Demolition of existing garage, side porch & roof level store & water tank & construction of a new side extension, new garage & second floor bedroom.

Broadbeach 39 Coastal Road Kingston

Thank you for your internet representation made on 24th June 2015 which has been recorded as '**an objection**' with the comments as follows:

1419 SK09B
Broad Beach 1:100
Proposed West & East Elevation
April 2015

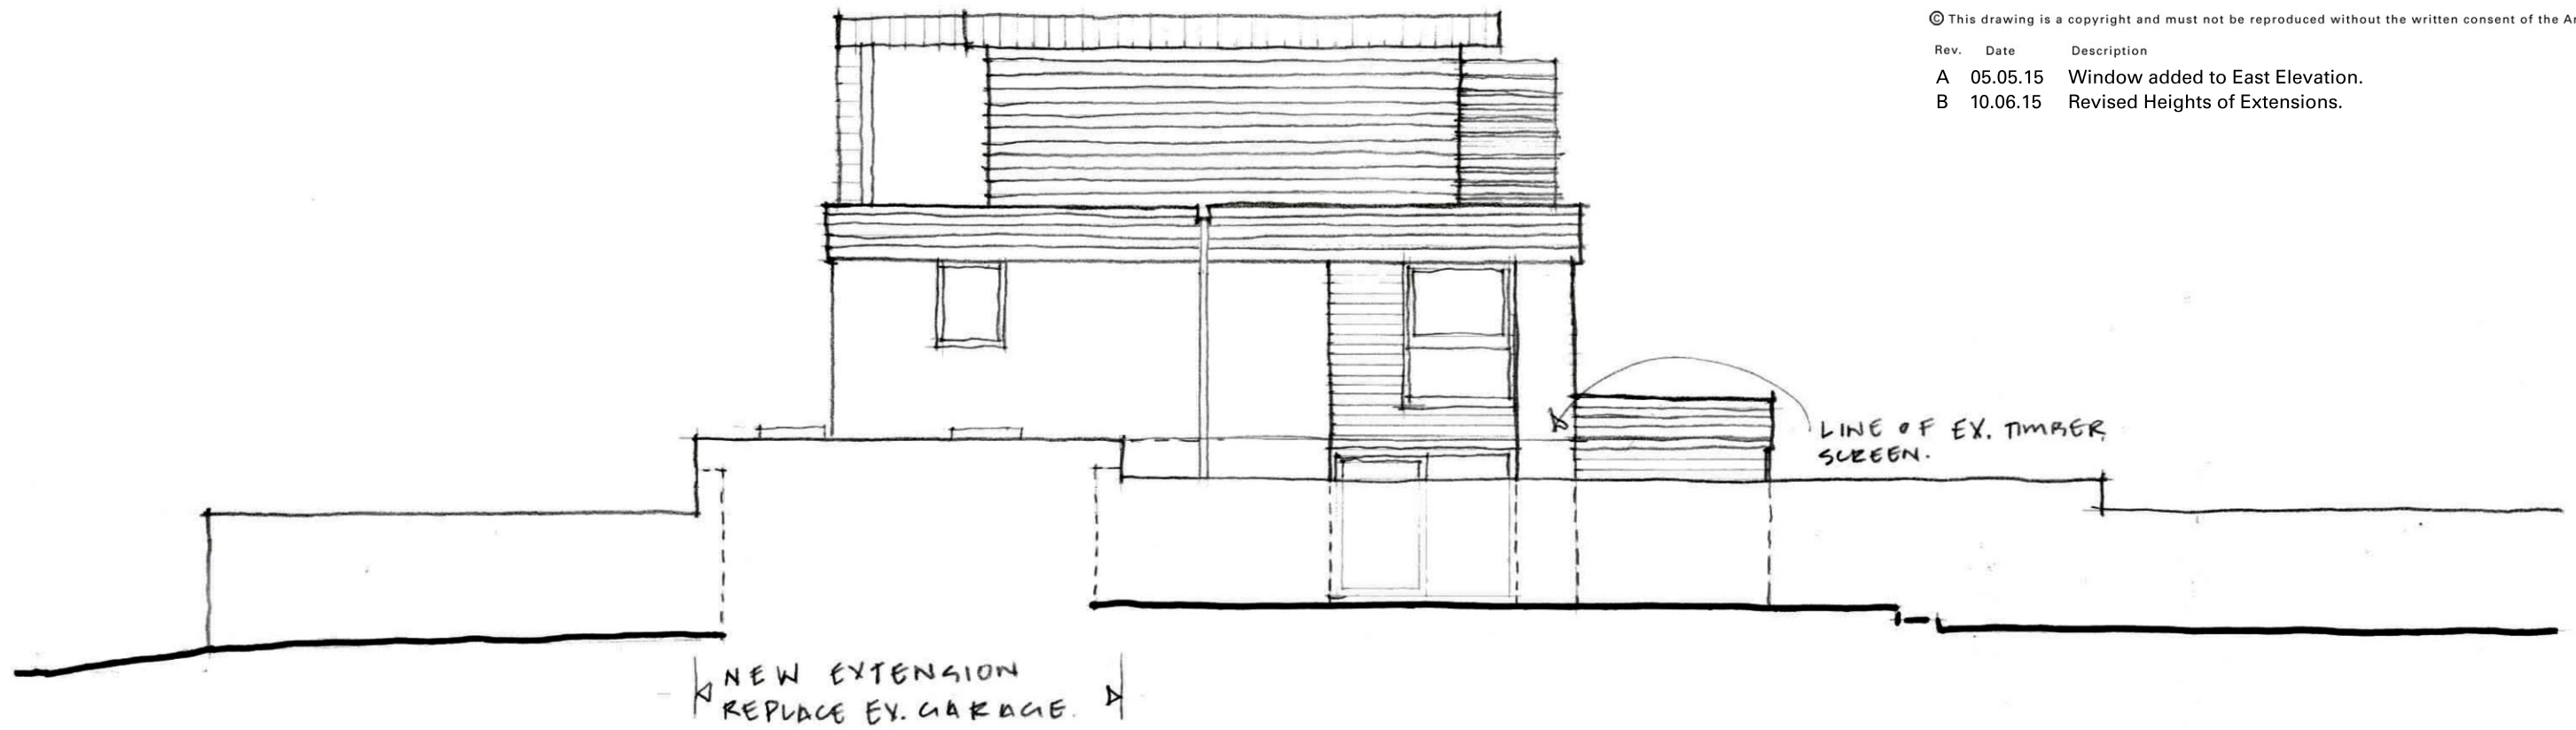
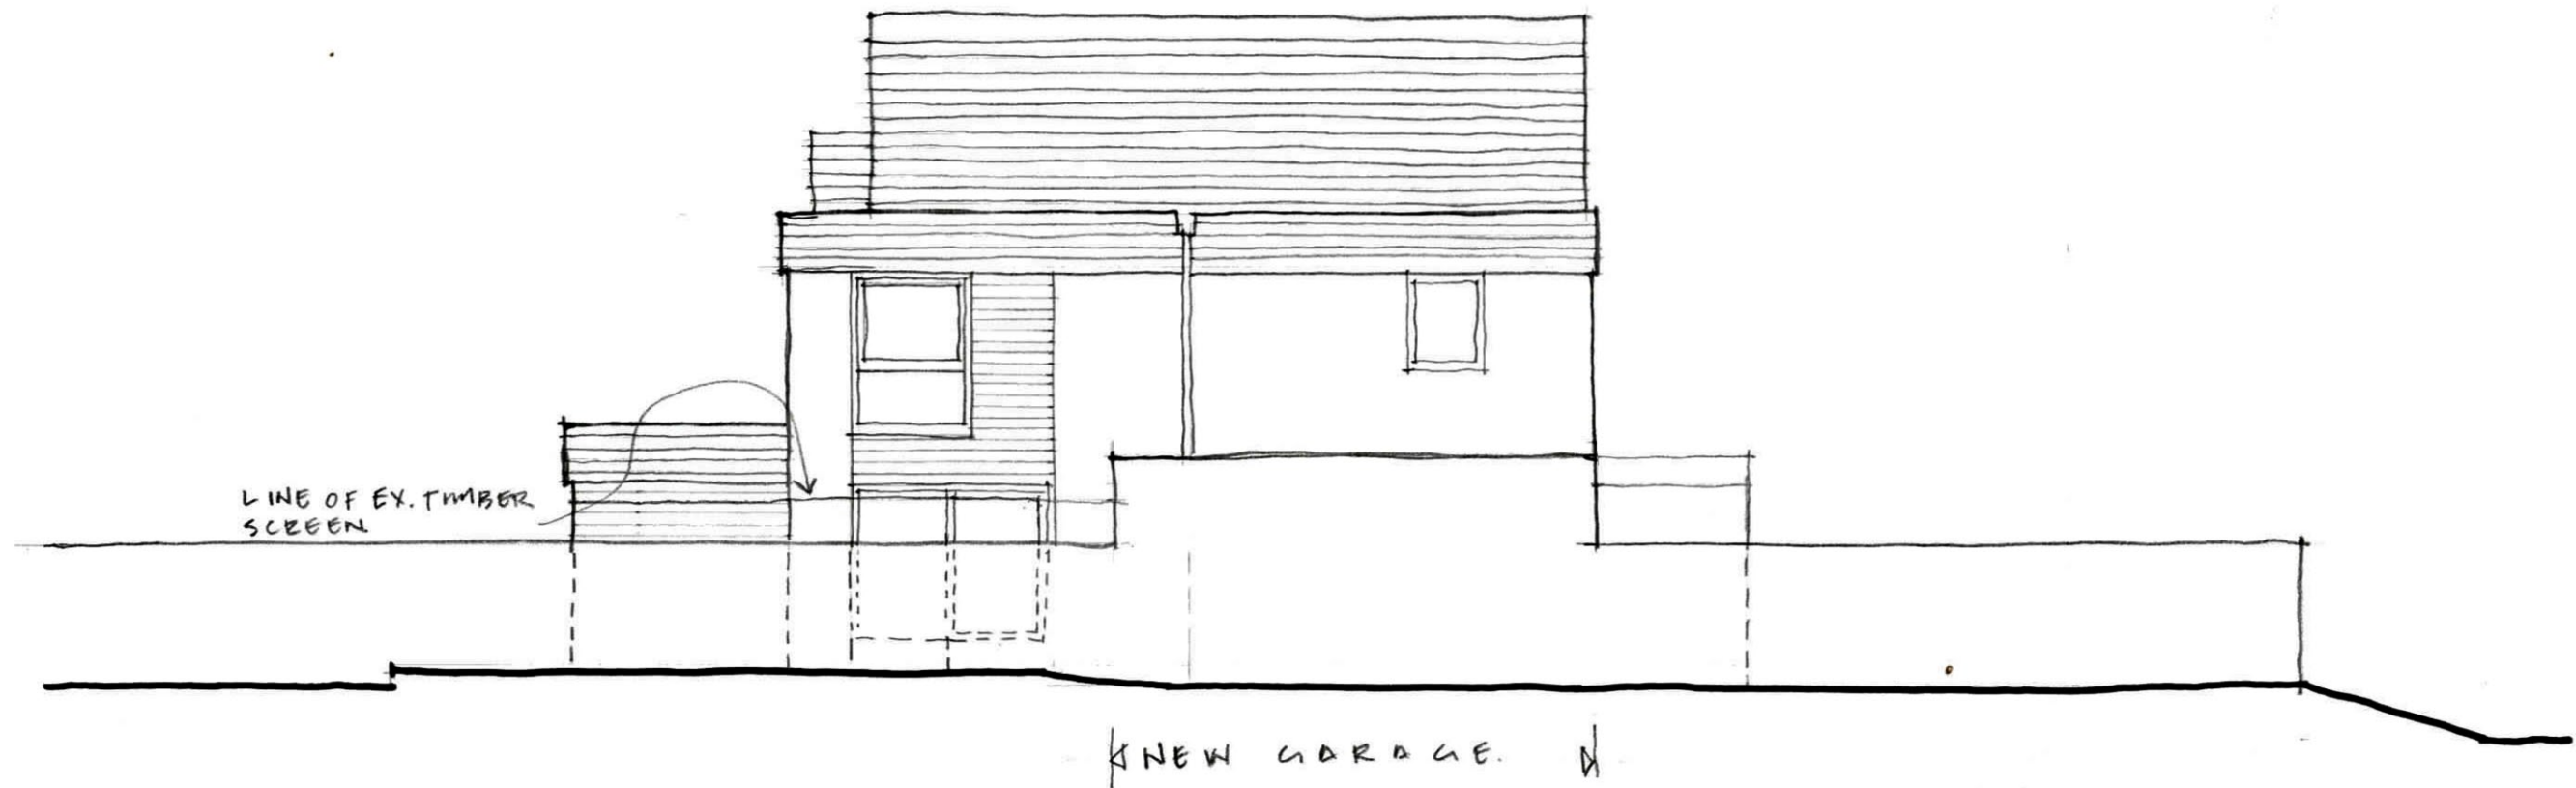
The minor modifications to the original proposal (i.e. reducing the height of the proposed west ground floor extension by 350mm) and the clarification that a privacy screen will be included in the proposed 3rd storey have mitigated our concern about being overlooked. However, there are still remaining issues of concern.

We would need to go to the expense of raising our dividing wall to minimise the impact of this proposal on our property as the proposed extension, which is "replacing" an existing garage, would be built directly against the dividing wall and exceed its height. We discussed this during our meeting with Mr Jones where he confirmed that it is necessary to increase the height adjoining our dividing wall in order to provide living accommodation in place of a garage.
